Recommendation Report for Planning Permission for Works or Extension to a Dwelling

REF NO: FG/145/25/HH

LOCATION: 25 Clover Lane  
Ferring  
BN12 5LZ

PROPOSAL: Single storey side extension with new front porch.

Proposed Elevations

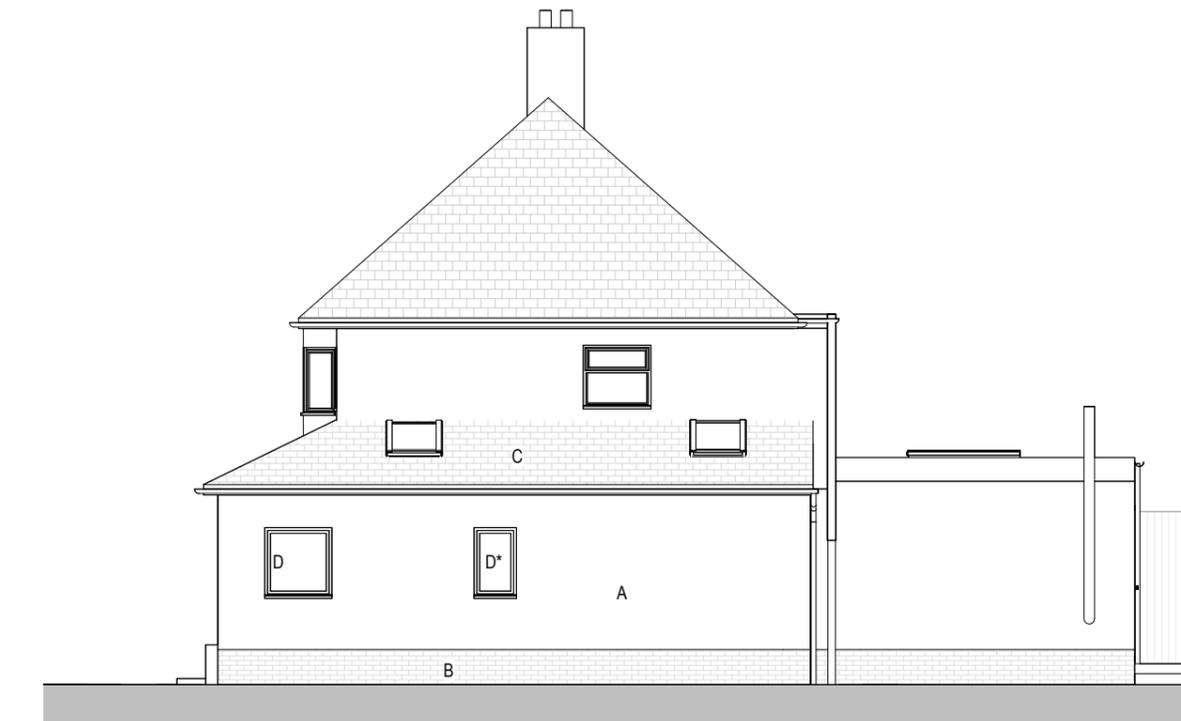
The single-storey side extension with new front porch would have a mono-pitched roof with a maximum approximate height of 3.8m and an approximate eaves height of 2.7m. On the side (west) elevation the mono-pitched roof would contain two rooflights positioned high in the roof slope, close to the abutment of the host dwelling.

The single-storey side extension and new porch would be finished with brick work on the lower plinth, rendered walls and roof tiles to match the host dwelling. Fenestration to the front (north) elevation would be a single entrance door. Fenestration to the side (west) elevation would be two single double-glazed windows, with the central window being obscurely glazed. Fenestration on the rear (south) elevation would be a single double-glazed door.

It is noted that the single-storey side (west) extension would be set back approximately 0.7m from the neighbouring side (west) boundary and would not comply with the minimum guidance of 1m for a single-storey extension outlined in the ADG policy M. However, given that the neighbouring (west) dwelling at No. 23 Clover Lane benefits from a similar form of development and existing high boundary treatment would remain, there would be limited the impact in overbearing or overshadowing to the neighbouring dwelling.

Fenestration on the front (north) elevation would have an outlook of the front amenity serving the host dwelling and fenestration on the side (west) would have an outlook of existing high boundary treatment, with the central window being obscurely glazed as it would serve a downstairs toilet. Fenestration on the rear (south) elevation would have an outlook of the host dwelling's rear amenity. To accord with Arun Design Guide Part M any roof light located on the roof slope of a side elevation should use obscured glass, therefore a condition is attached to this planning permission to maintain the privacy of the neighbouring properties. On balance, the proposed single-storey side extension and new porch would not result in loss of privacy or overlooking to the neighbouring dwellings.

- 3 Any roof light located on the roof slope of a side (west) elevation shall at all times be and remain glazed entirely with obscure glass to a level equivalent to Pilkington Level 3 or nearest equivalent standard. This arrangement shall be retained permanently thereafter.
